## Weather Event Inspection

Site Name:	<u>Kidz Academy Preschool &amp; The Human Bean</u> <u>7700 Sage Rd SW, Albuquerque, NM 87121</u>	Inspector:	Jeff Hart
Permit #:	NMR1003NO NMR1003NP NMR1003NL	Inspection Frequency:	
Date of Visit:	May 10, 2021, 12:30:21 PM	Last Rain Event Saturday, May 8, 2021, 0.0"	Last Precipitation Saturday, May 8, 2021, 0.88" 48h Forecast --

TEMPORARY EROSION AND SEDIMENT CONTROL PLAN

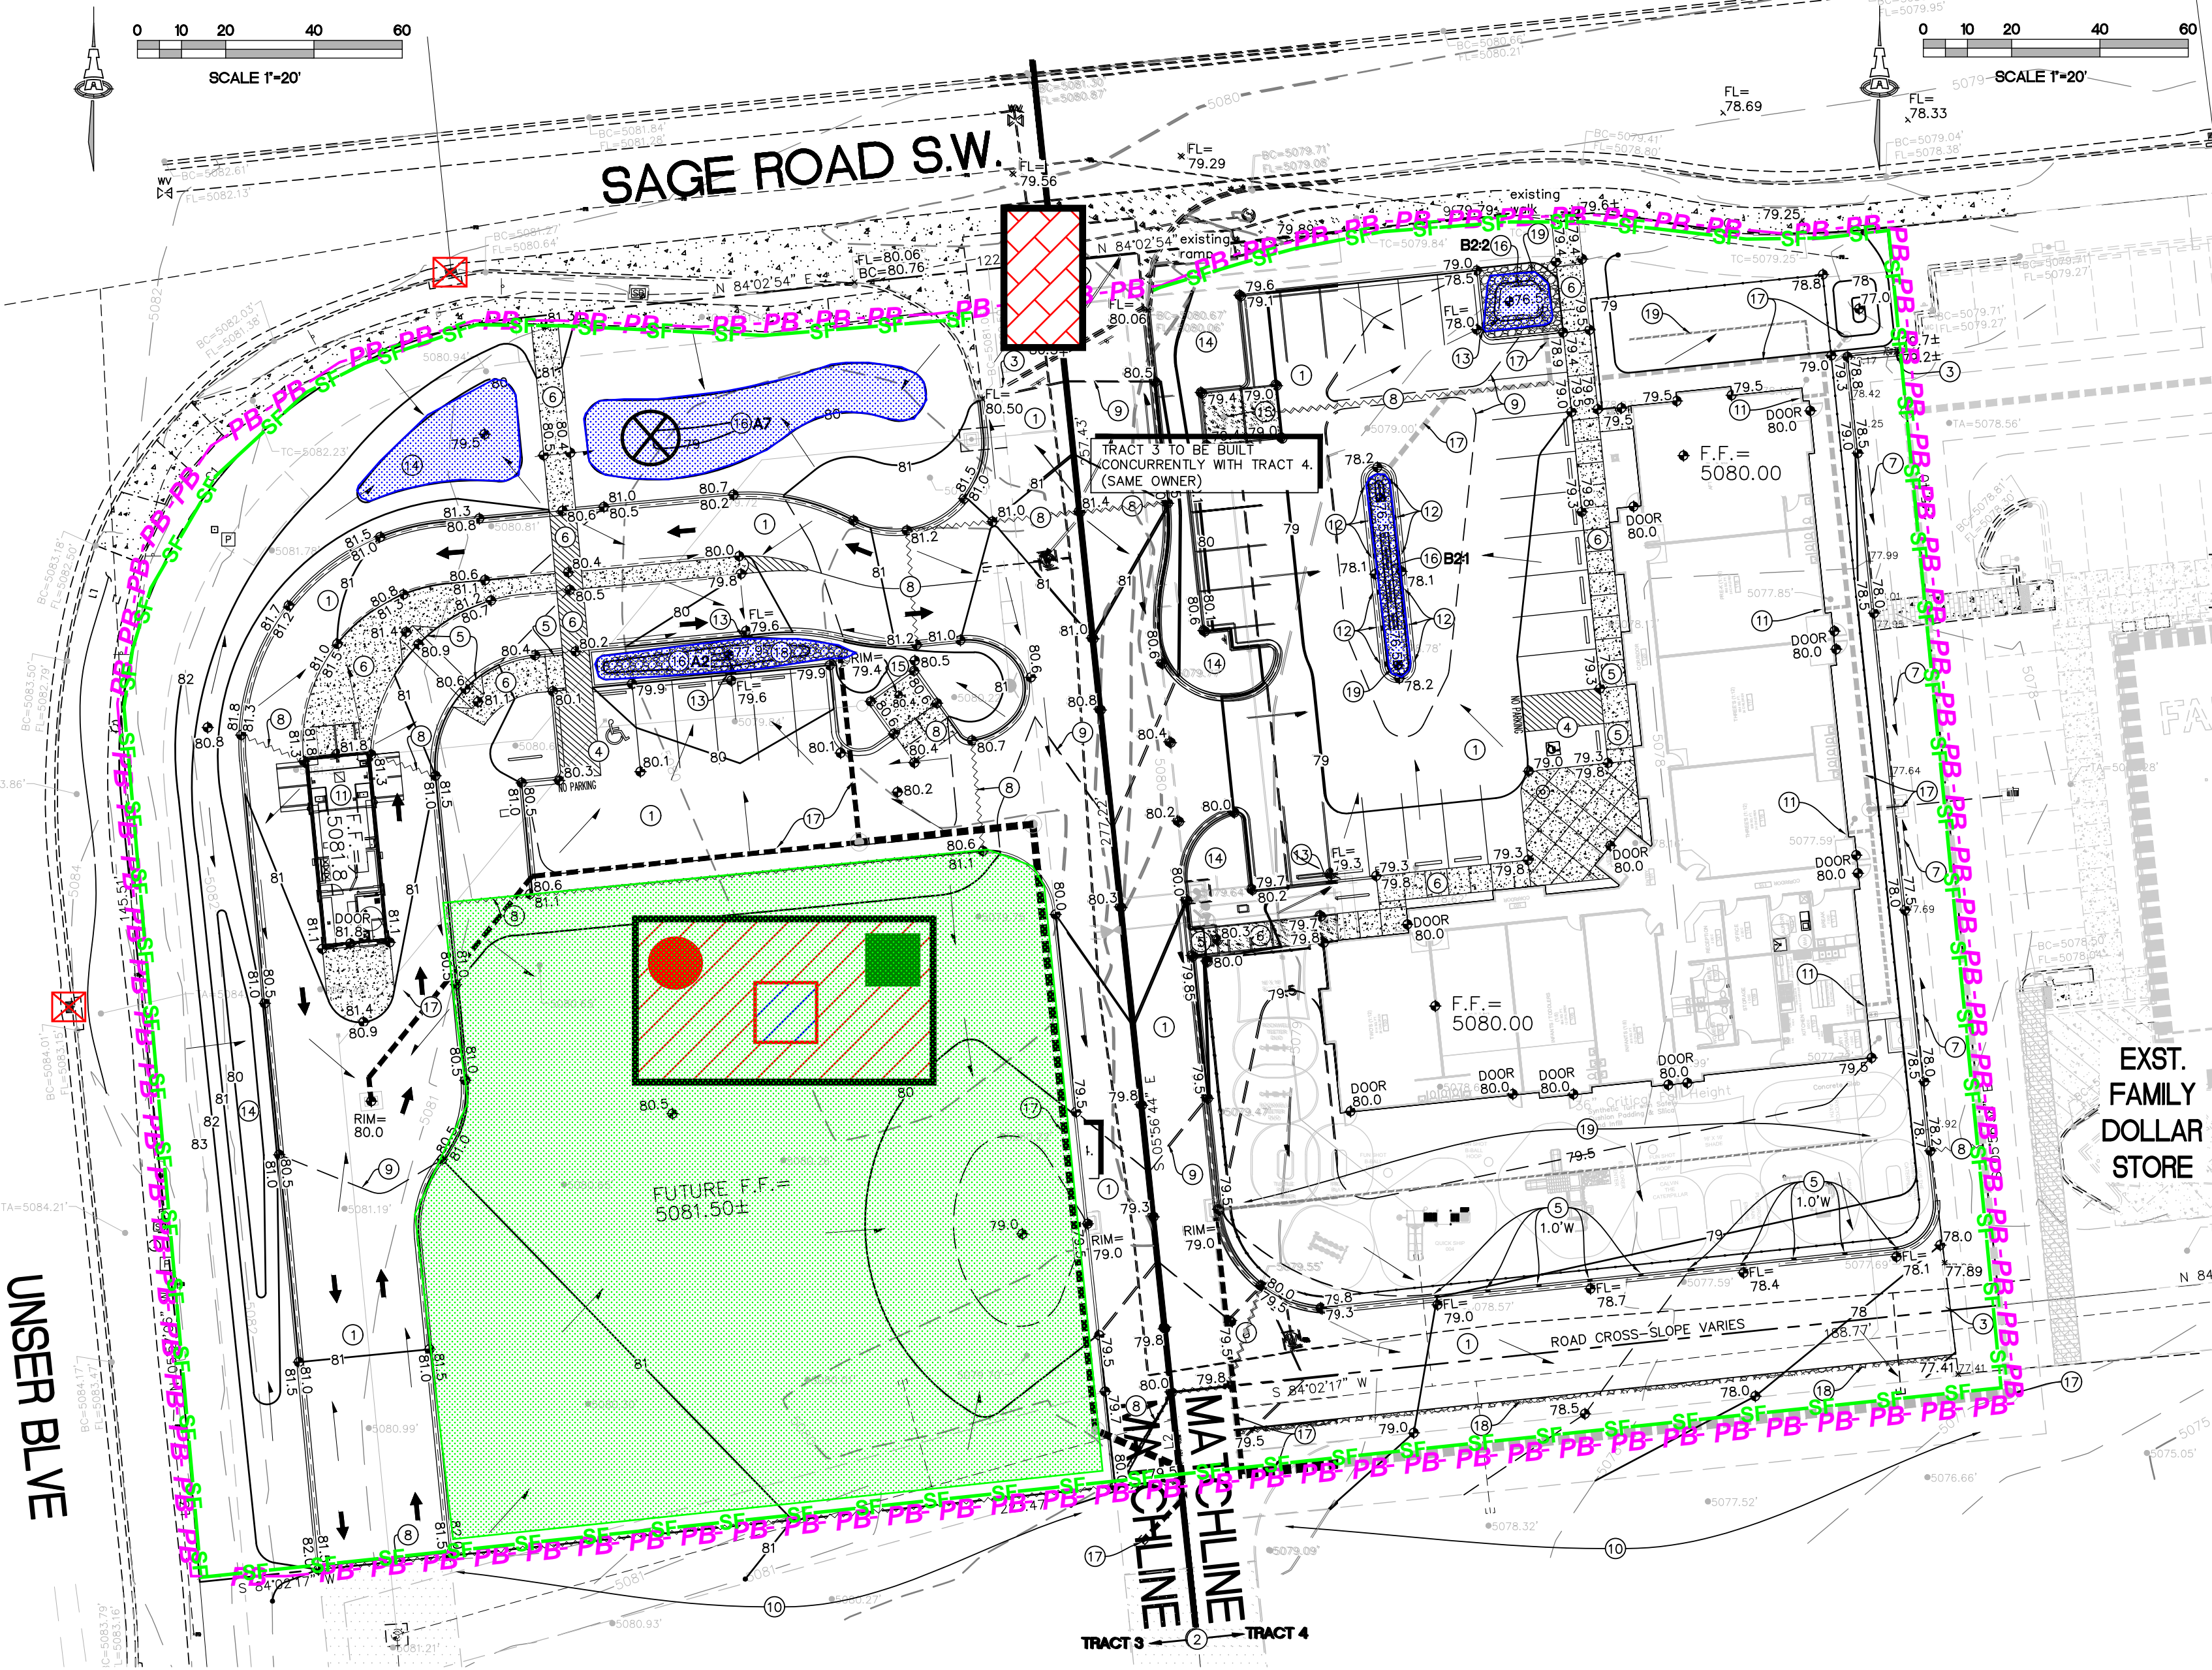
Remove dirt against the silt fence along the east property. Dirt must be below half the height of the silt fence. SE access point closed off by security fence, replace removed silt fence from this area or provide similar BMP.

Security fence in place. Remove dirt against the silt fence along the east property. Dirt must be below half the height of the silt fence. SE access point closed off by security fence, replace removed silt fence from this area or provide similar BMP.
